Technical Review – Surface Water  
Assessment (SSD-5765)

# TECHNICAL REVIEW - SURFACE WATER ASSESSMENT (SSD-5765)

| <b>Project:</b> | N1221_001 Bowdens Silver Surface Water Review | <b>Date:</b> | 27 July 2020 |
| <b>Subject:</b> | Surface Water Review – Technical Comments     |              |              |

Figure 7.27 - 1% (1 in 100) AEP predicted impacts on peak velocities along Lawsons Creek in the vicinity of the proposed Lawsons Creek Crossing - Lawsons Creek Crossing Scenario

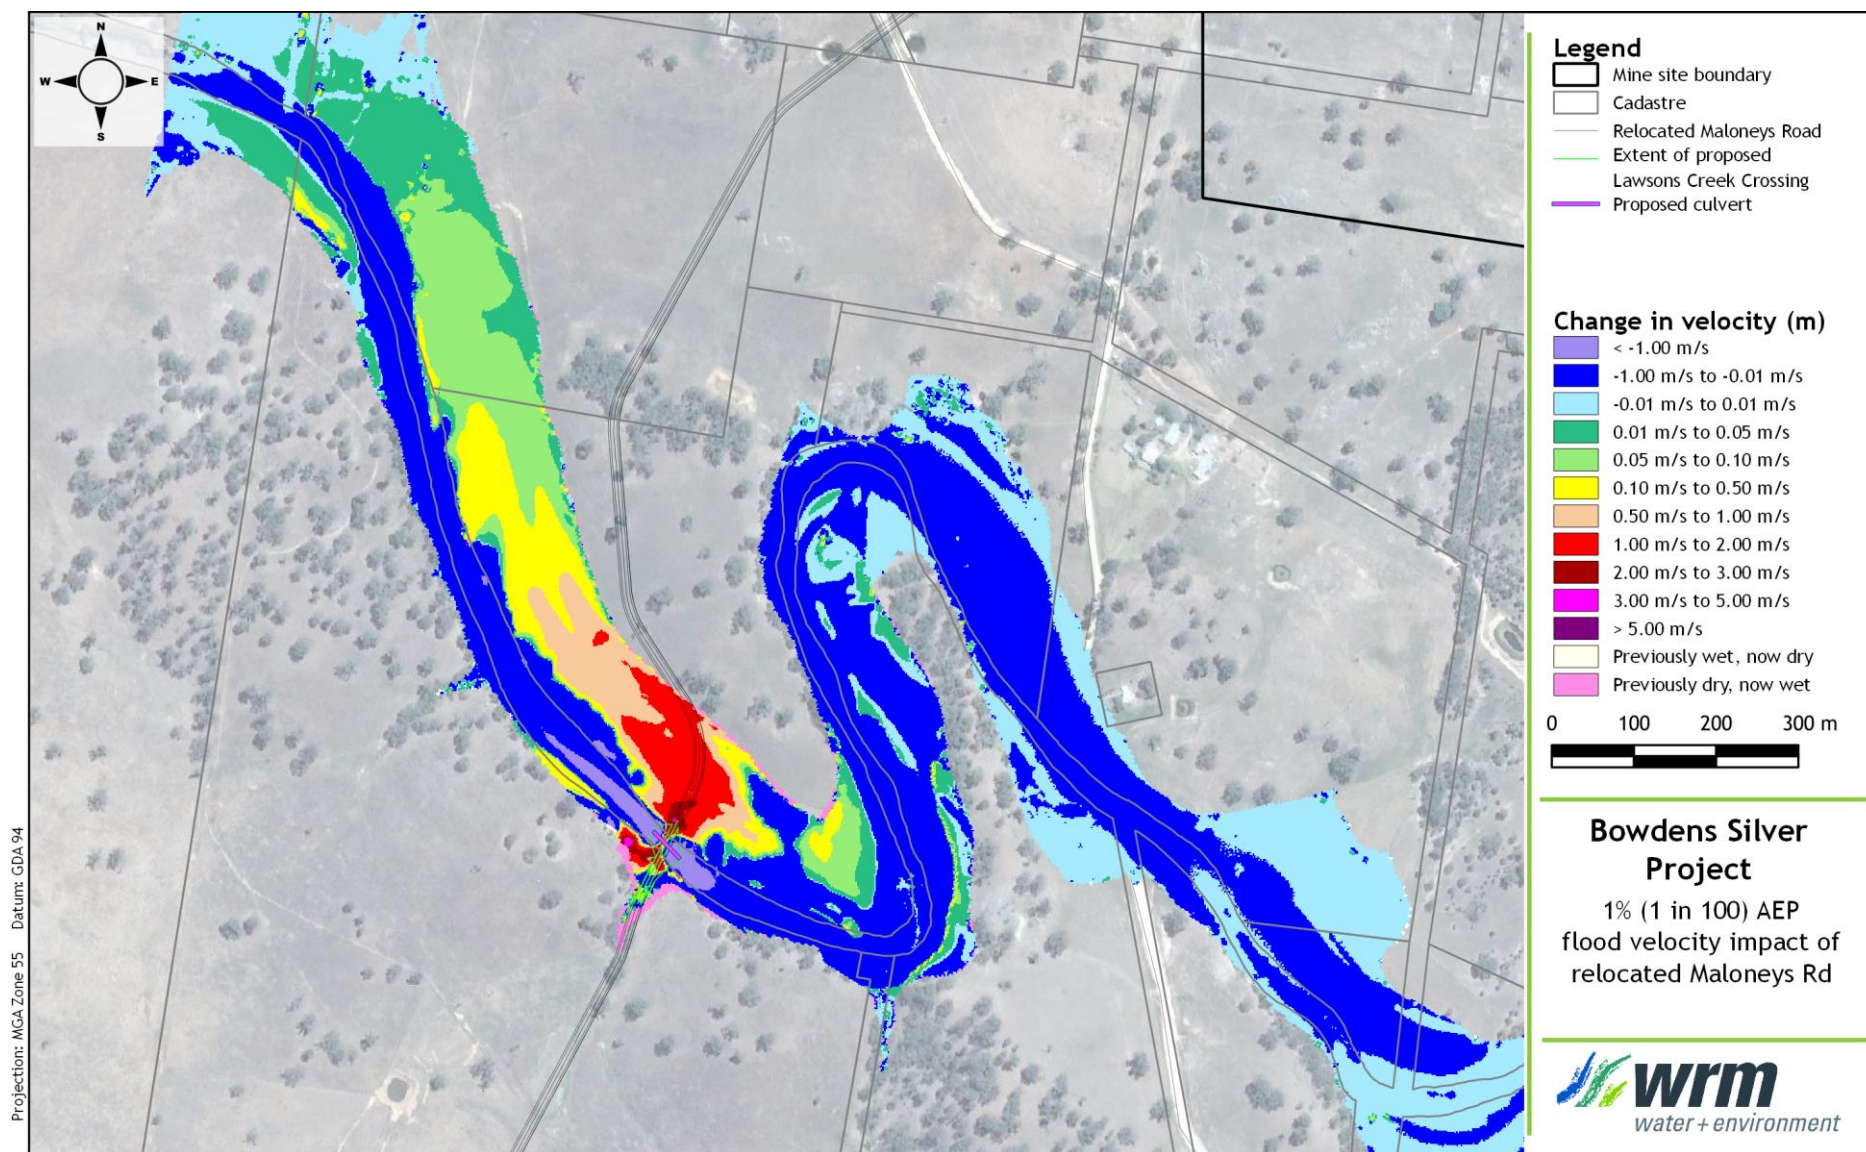
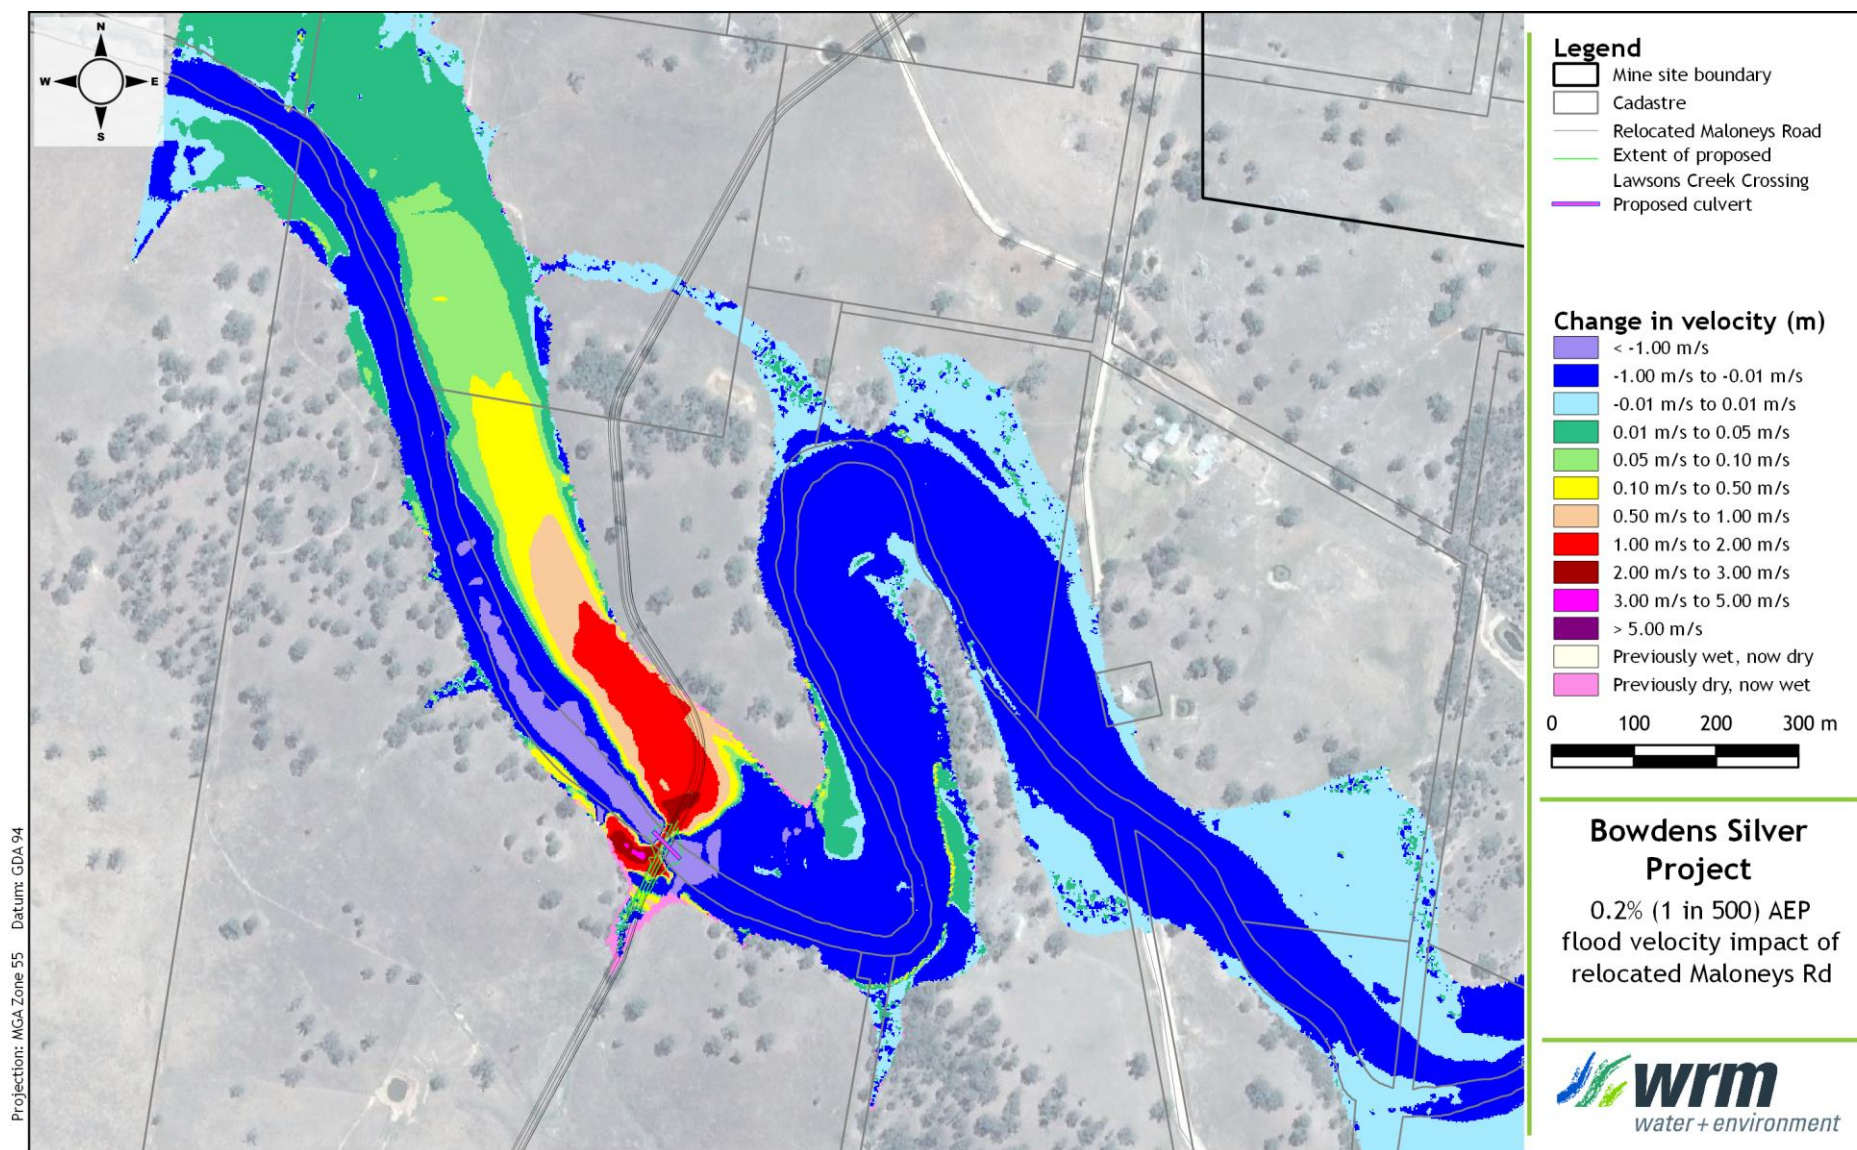
The assessment of flood risk for existing Maloneys Road crossing is not included in the assessment and as such there is no ability to compare the proposed crossing to the existing crossing. The modelling indicates that the proposed crossing will result in increases in flood depths of 1 to 2 m upstream of the new crossing in the 10% Annual Exceedance Probability (AEP) event, as well as a breakout occurring that is not present in the existing conditions. More information on the acceptability of the potential impacts of the flood risk and the breakout should be provided.

| Section  | Aspect  |
|--|---|
| Section 6 Flood Impact Assessment                      | <p>Predicted increases in depths – not clear whether this is land owned (or option to own) by Bowden Silver. Changes in flood depth upstream of new crossing and associated new downstream breakout zone have no clear comparison to the existing crossing accessibility and floodplain capability.</p> <p>Increase in velocities predicted in some locations requiring permanent stabilisation. Insufficient detail on where these are and the required stabilisation methods. Uncertain if the stabilisation can be established, considering the mobile creek systems described in Annexure A.</p> <p>These aspects need to be considered in more detailed in both the operational and post closure scenarios.</p> <p>No afflux mapping or analysis for smaller events.</p> |
